COLORADO

Parks and Wildlife

May 23, 2025

Re: 4-Way Commercial Site Development Plan

A FENCE TYPE A: ALUMINUM SPEAR-TOP
SCALE: N.T.S.

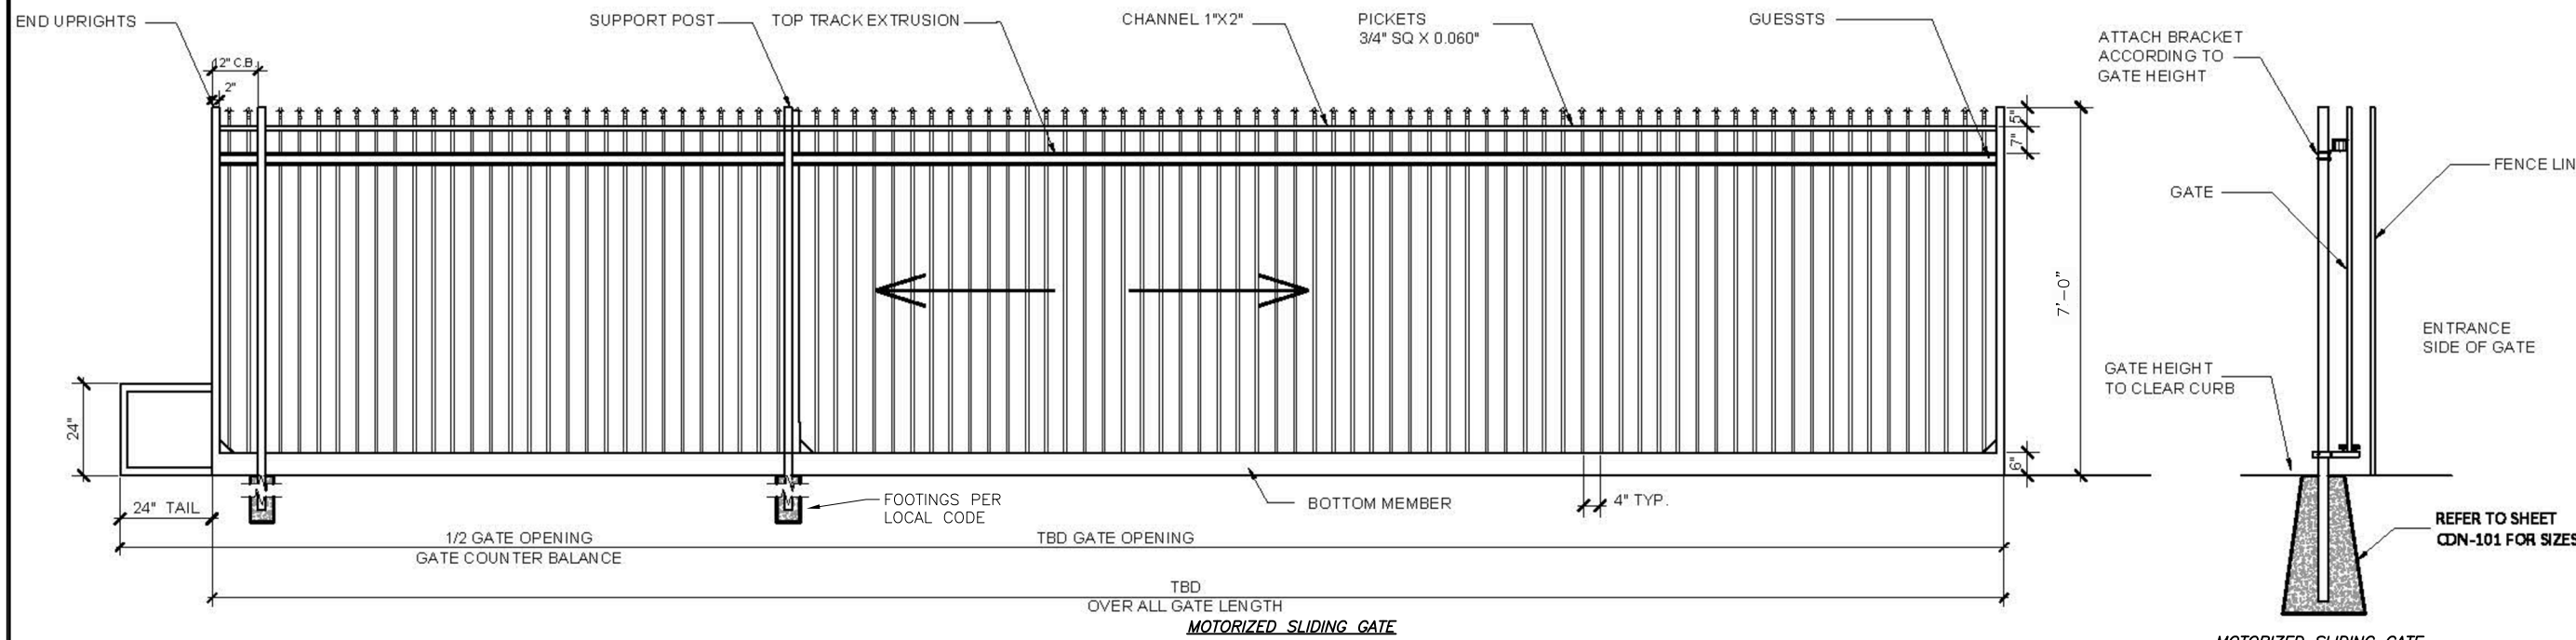
It was noted in the "Landscape Plan Drawings" document that a fence described as, "FENCE A - 7' HT ALUMINUM SPEAR-TOP". The fence being 7 feet tall is good for exclusionary purposes related to wildlife, however the spear top is concerning. If the fence is a rod-iron style it can also cause issues with wildlife entrapment. Construction of ornamental wrought iron fencing with closely spaced vertical bars (<12") and sharp projections extending beyond the top horizontal bar should be strongly discouraged in areas where deer, elk, and pronghorn are known to occur. This type of fencing typically ensnares deer and elk by the hips when trying to squeeze through and impales animals attempting to go over the top. It should be noted that it is very distressing to find wildlife in or impaled on fences.

construction. Construction of ornamental wrought iron fencing with closely spaced vertical bars (<12") and sharp projections extending beyond the top horizontal bar should be strongly discouraged in areas where deer, elk, and black bear are known to occur. This type of fencing typically ensnares deer and elk by the hips when trying to squeeze through and impales animals attempting to go over the top. It should be noted that it is very distressing to find wildlife in or impaled on fences.

CPW further recommends the developers consult our publication Hanophy, Wendy "Fencing with Wildlife in mind." CPW.state.co.us. 2009 when considering the design of fences within the development. The publication is available on our website and we would be happy to provide a link to the PDF specifically. The use of privacy fencing, chain link fencing, and other exclusionary fencing should be at least 6 feet high and should be restricted to the immediate area surrounding the buildings or within the designated building envelope and should not be used as a method to designate boundaries of larger lot sizes (> 1 acre). Fencing outside the immediate building envelope or area surrounding the buildings on larger lots within the known range of elk, deer and pronghorn should be a maximum top height of 42" with at least 12" spacing between the top two wires or rails and a bottom wire or rail at least 16" above the ground to allow passage of juvenile animals and pronghorn antelope. It is also recommended that the top and bottom wires be a twisted barbless type or smooth wire or rail
